CITY OF PORTLAND, MAINE
DEVELOPMENT REVIEW APPLICATION
PLANNING DEPARTMENT PROCESSING FORM

Project Name/Description

100 - 100 Hope Ave , Portland, Maine

From: Jay Reynolds
To: Doug Reynolds
Date: Mon, Oct 25, 2004 3:09 PM
Subject: Review Comments:

0102

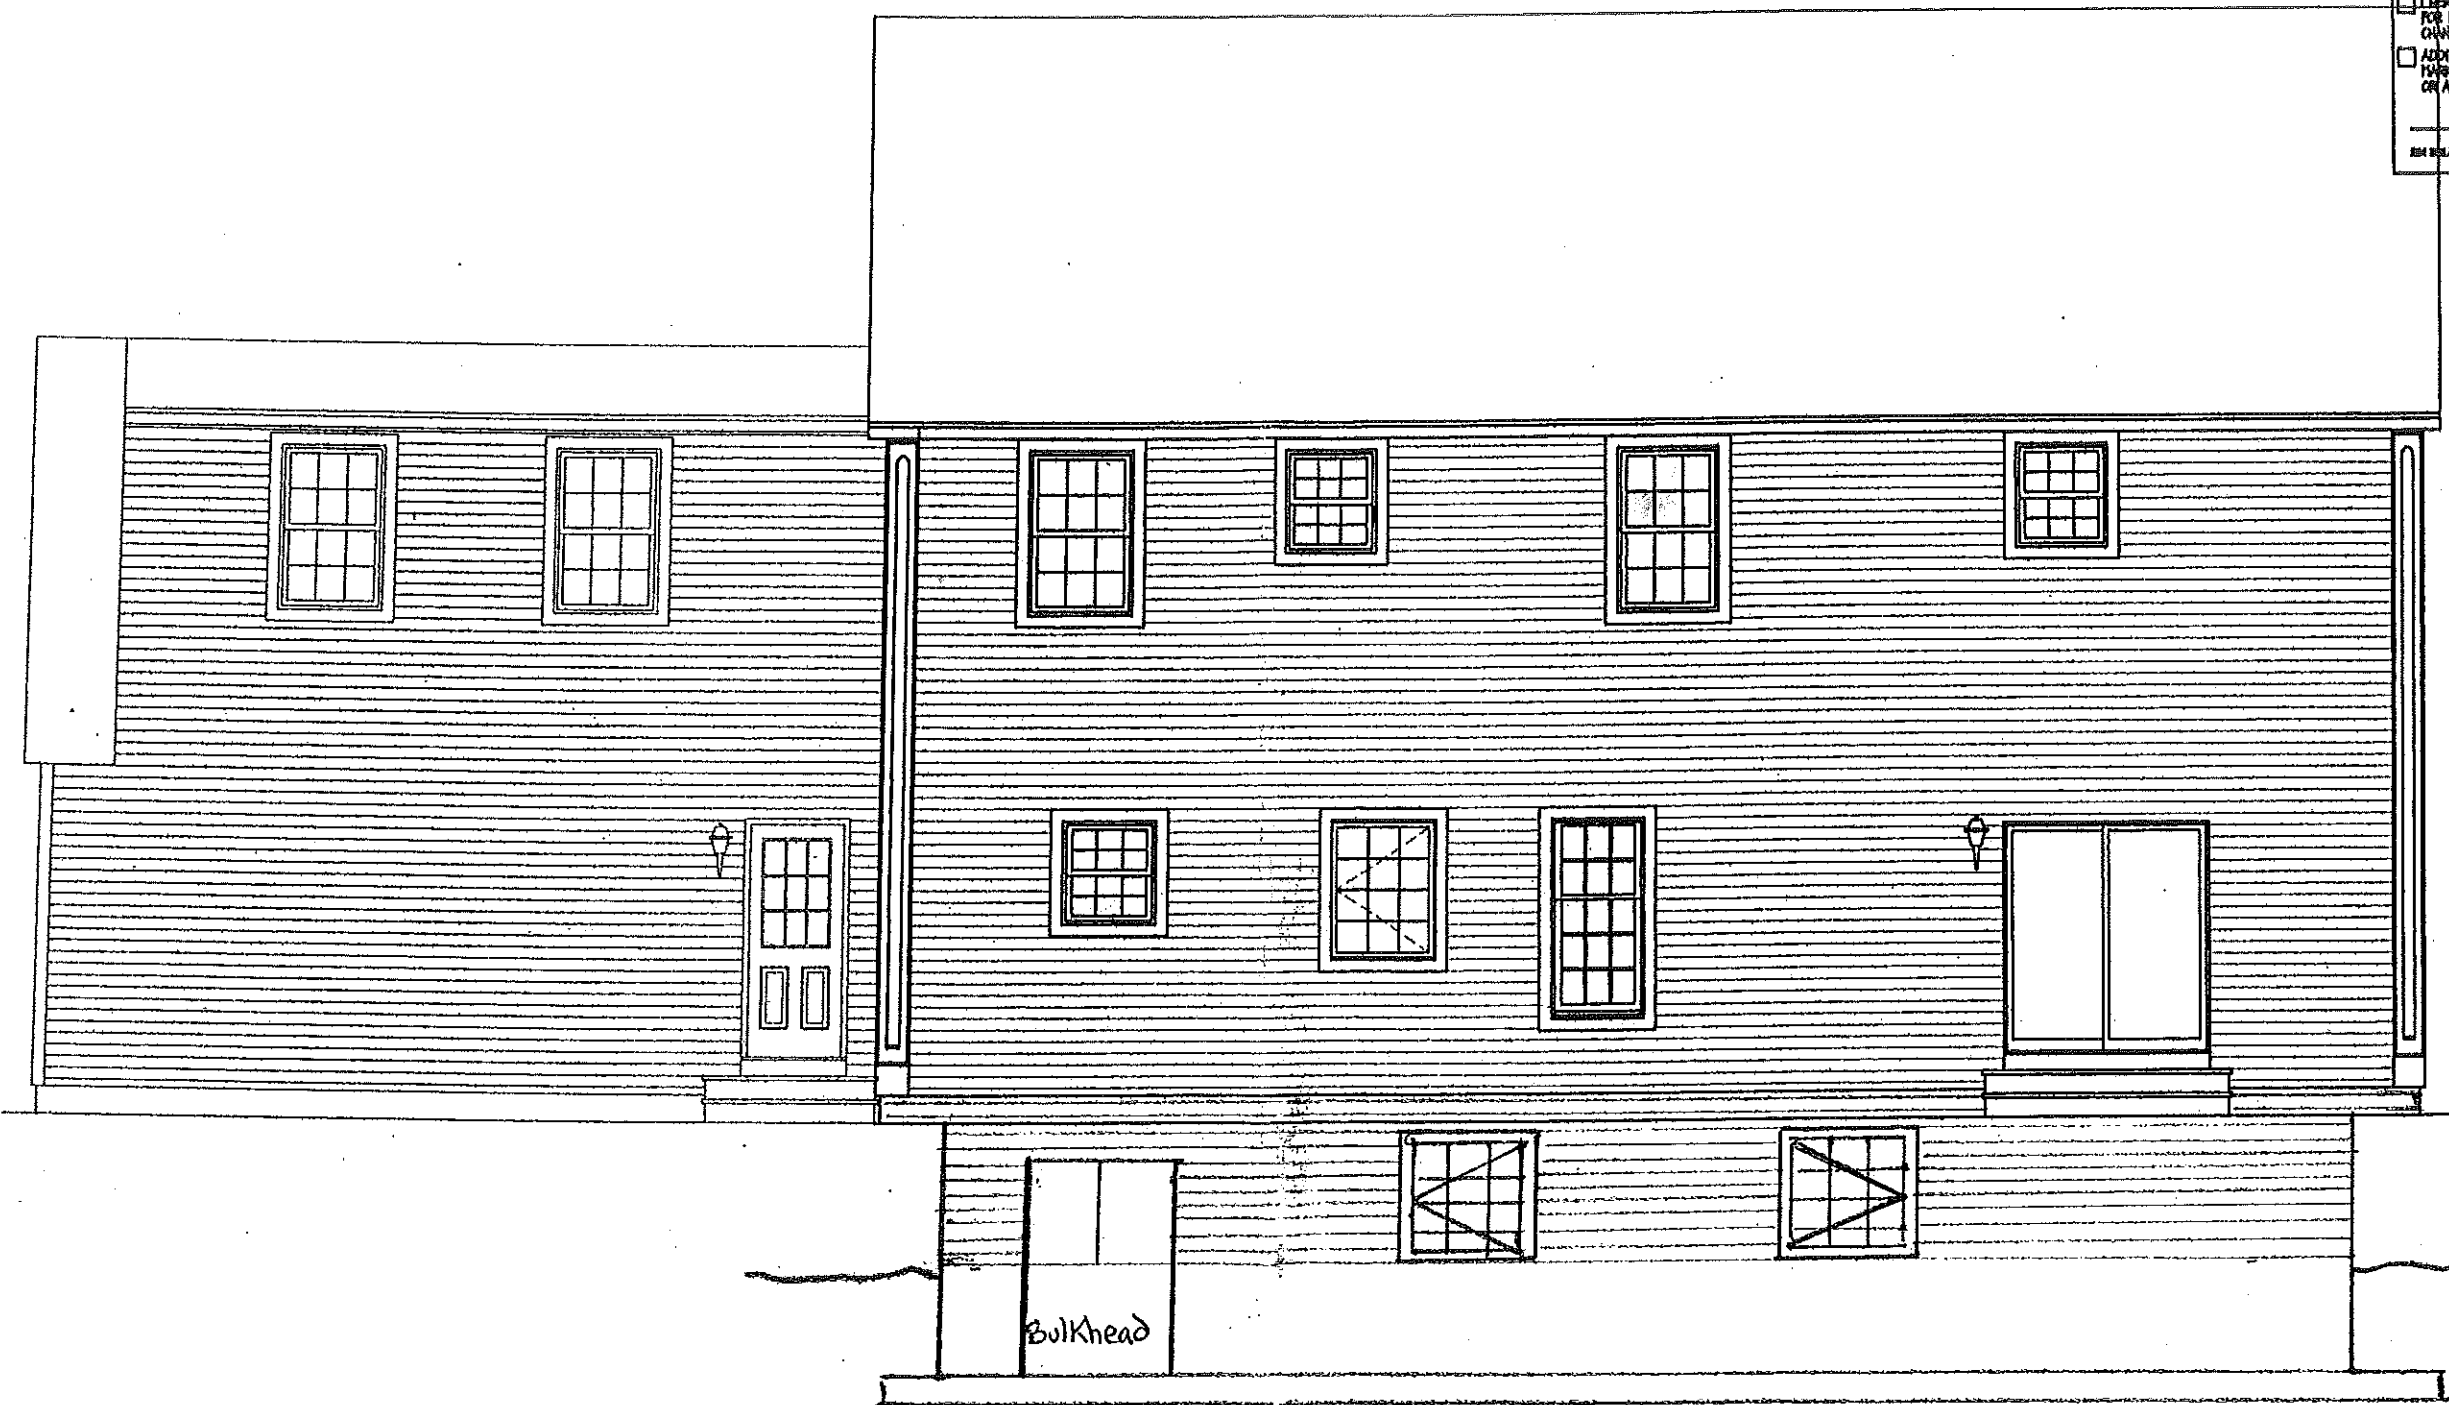
1. The building elevations don't match the site plan. Site plan indicates that there's 4.5' of wall showing in the rear, however, the building elevations show a few steps out the back. Please clarify.
2. The building elevations don't match the site plan. Is there a deck or a set of stairs in the rear? Please clarify.
3. Please remove 'zig-zag' in utility lines. It looks like the utilities can be run in a straight line from the stubs to the building.
